**Harnett County**  
108 EAST FRONT STREET  
LILLINGTON, NC 27546  
Phone:  
Fax:

**SUBJECT: SFD1909-0031**  
**SINGLE FAMILY DWELLING**

Here are the results of all Inspections located at **12820 NC 27 W:**

FRONT ELEVATION
SCALE 1/4" = 1'0"

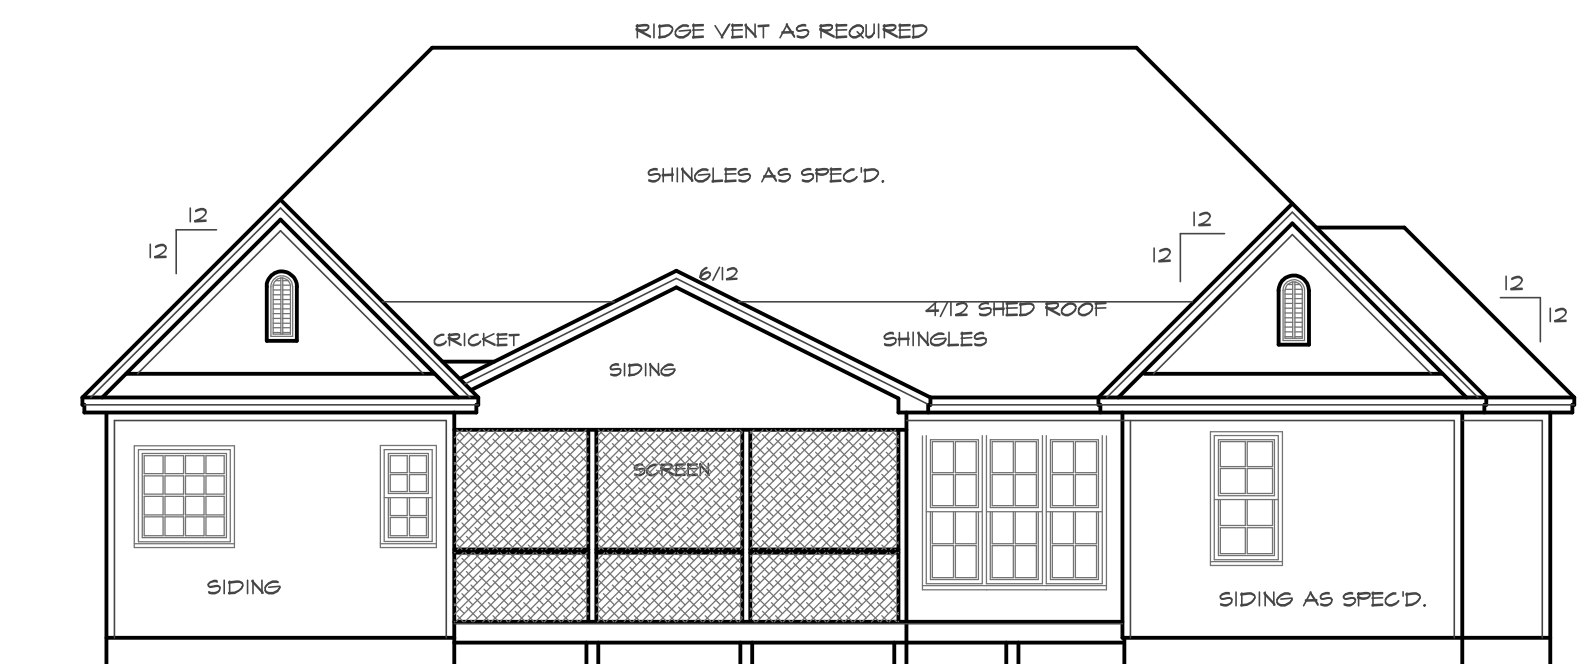
Note: siding already installed. Flash front porch. Missing wind bracing on a, e and d trusses. Leaking drain piping under kitchen in crawlspace. Ok to insulate.
